**ADC Planning Consultation
Response from the Historic Buildings Adviser**

Application Number	BE/61/14/HH
Address	99 North Bersted, Bognor Regis
Description	Two storey extension.
Case Officer	Janice Chapman
Site Visit

NEW NORTH EAST ELEVATION

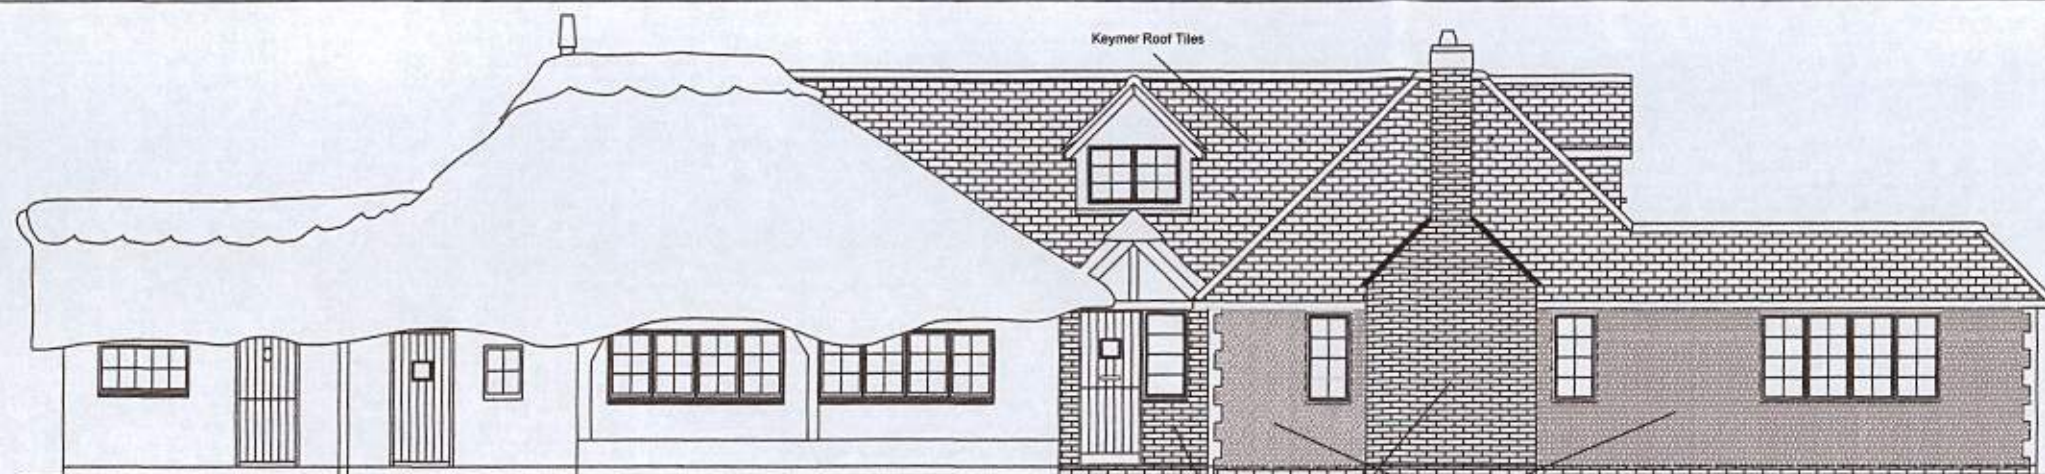
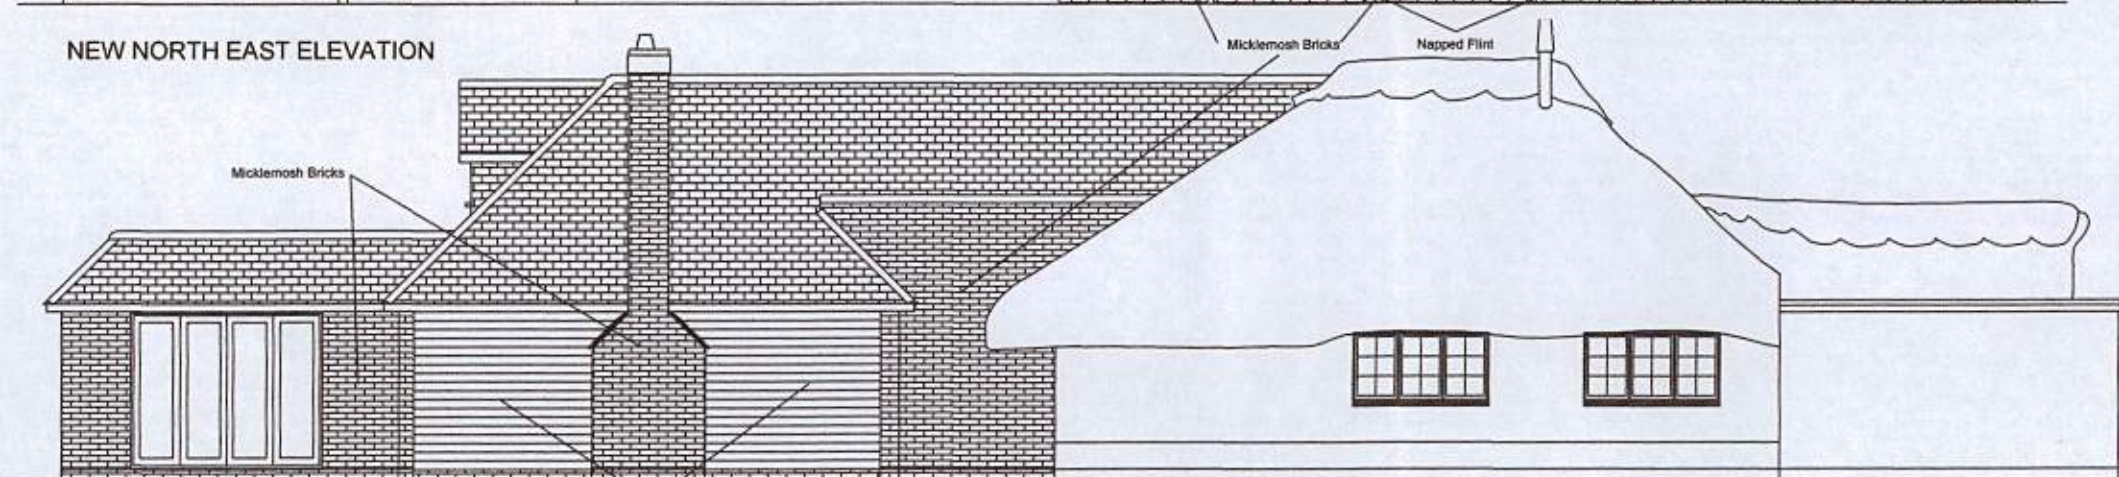
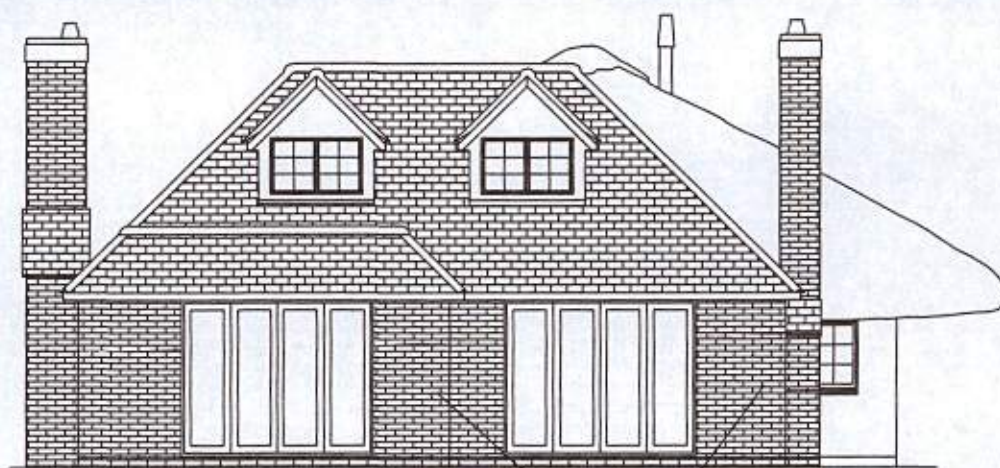
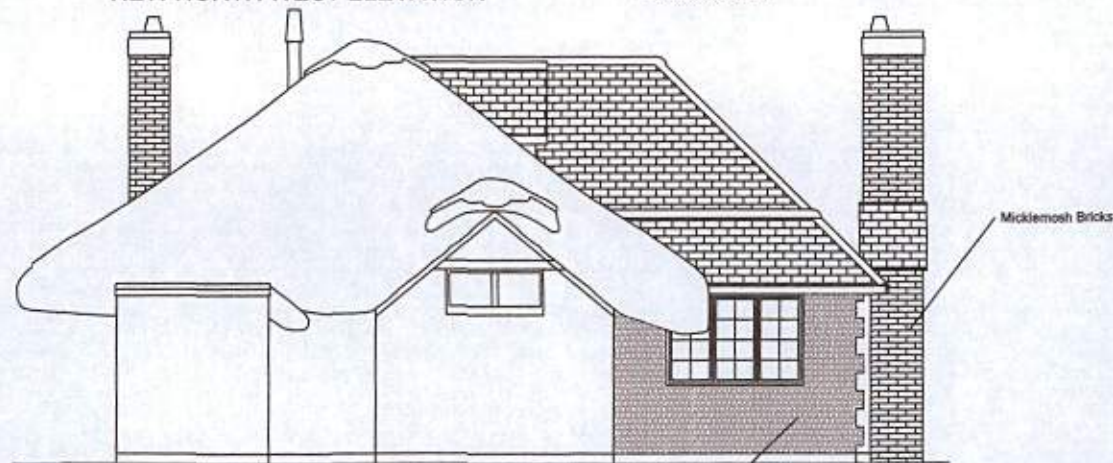
its scale, form and design. It does not respect the existing building and is certainly not subservient to it. The footprint appears at least the same size, if not larger, whilst the new roof encroaches onto the cottage in a manner that is not sympathetic. The complexity of the new building is also problematic.
